**Re: Hannah Ridge at Feathergrass Filing No. 3 Final Plat- SF-17-012 - Review 2  
Project No. 60970-F3**

M.V.E., Inc. has prepared the following response to comments contained in your August 29, 2017 comment letter concerning the above named project. Revised submittal materials are enclosed as needed. Each comment is addressed below in the order contained in your comment letter.

HANNAH RIDGE AT FEATHERGRASS
FILING NO. 3
GRADING AND EROSION CONTROL PLAN

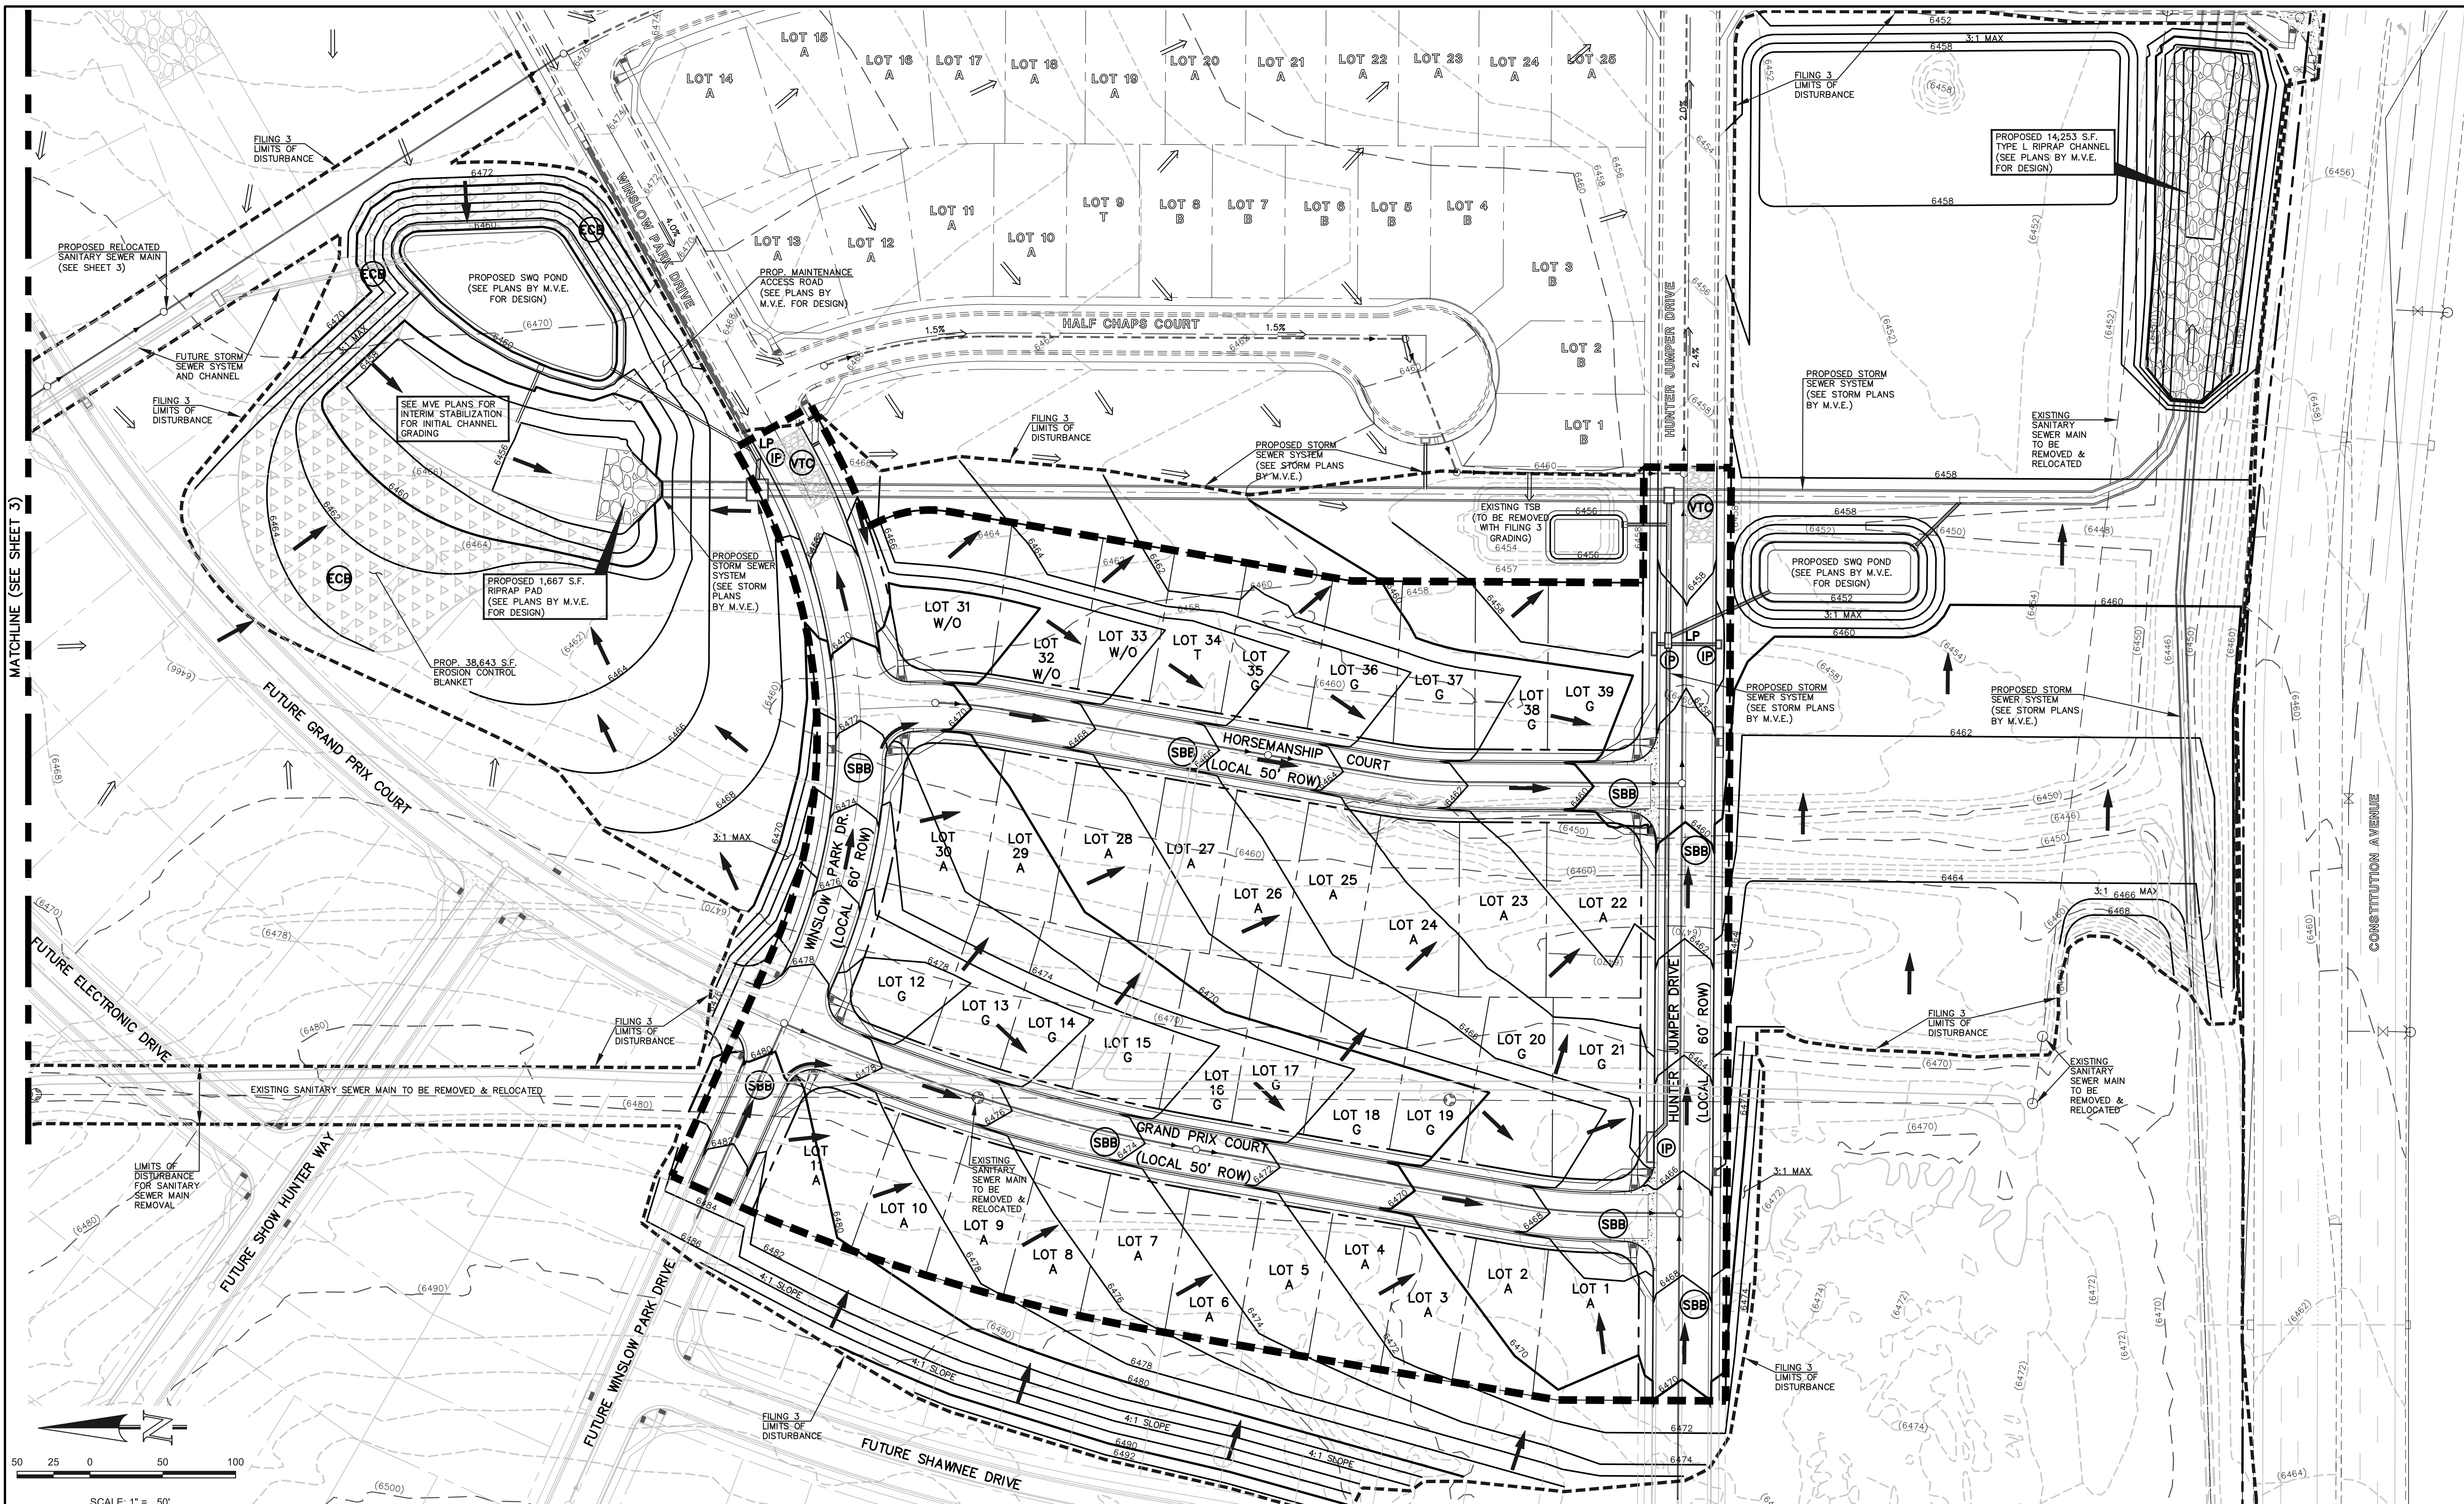
1. **Resolved**
2. Include all areas to be graded or disturbed with this filing, including storm drainage and utilities to be constructed with Filing 3. Clearly label offsite construction areas. **Comment remains regarding the offsite culvert. Response: Addressed by Classic Consulting.**

4. *The SWMP references silt fence perimeter control and the GEC notes on Sheet 3 discuss maintenance but no silt fence is shown on the GEC plan, which only appears to show inlet protection and erosion bales for sediment control.*

- a. *Based on the area of disturbance, additional sediment controls appear to be required; revise the GEC plan as appropriate. **Comment remains; coordination between the GEC/SWMP and construction plans is required regarding TSBs specifically. Response: Coordinated and addressed.***

HANNAH RIDGE AT FEATHERGRASS FILING NO. 3 OVERLOT GRADING PLAN INCLUDING EROSION CONTROL - TITLE SHEET			
DESIGNED BY	KRC	SCALE	DATE 04/11/17
DRAWN BY	MES	(H) 1"=VARIES	SHEET 1 OF 3
CHECKED BY	(V) 1"= N/A	JOB NO.	1116.00

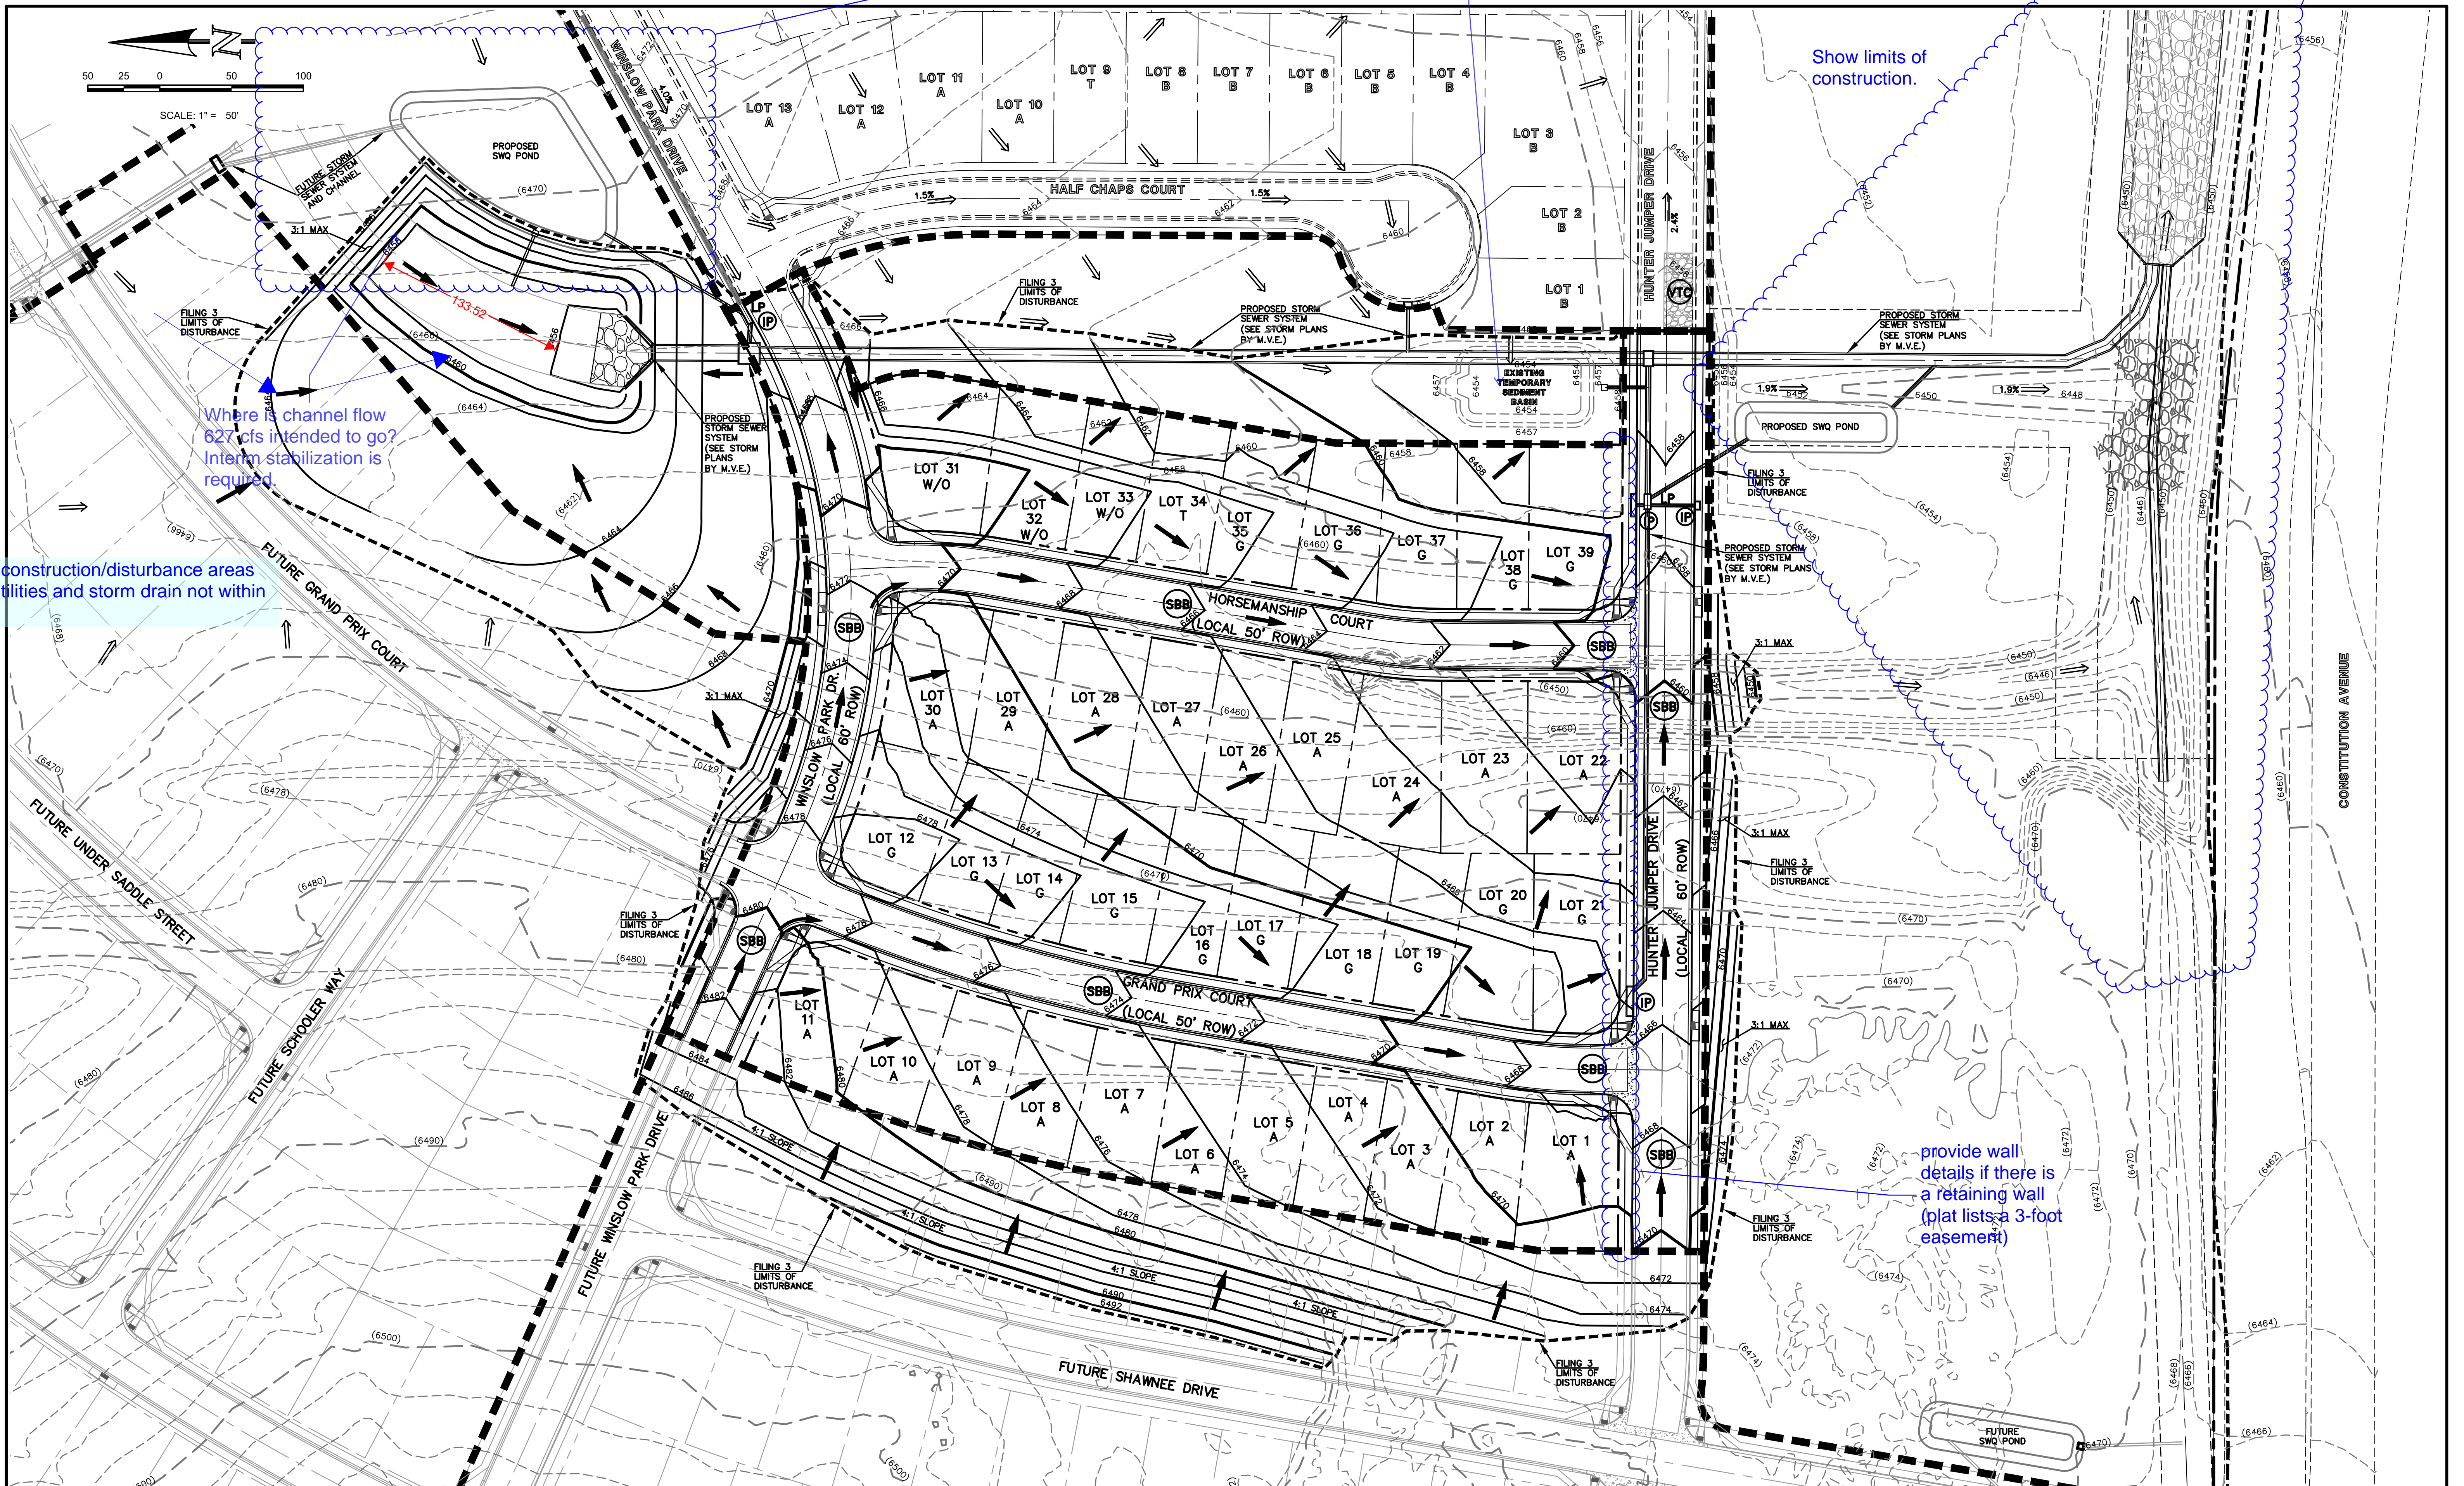
The plan received is titled as "Overlot Grading Plan Including Erosion Control". If this will be the only Grading and Erosion Control Plan for this filing, revise the title to include "Grading and Erosion Control Plan." **Unresolved.**

- b. *Address temporary sediment basins in all applicable documents. **Comment remains.***
5. *SWMP:*
  - a. **Resolved**
  - b. **Resolved**
  - c. *Ensure that all checklist items (previously attached) are provided.*
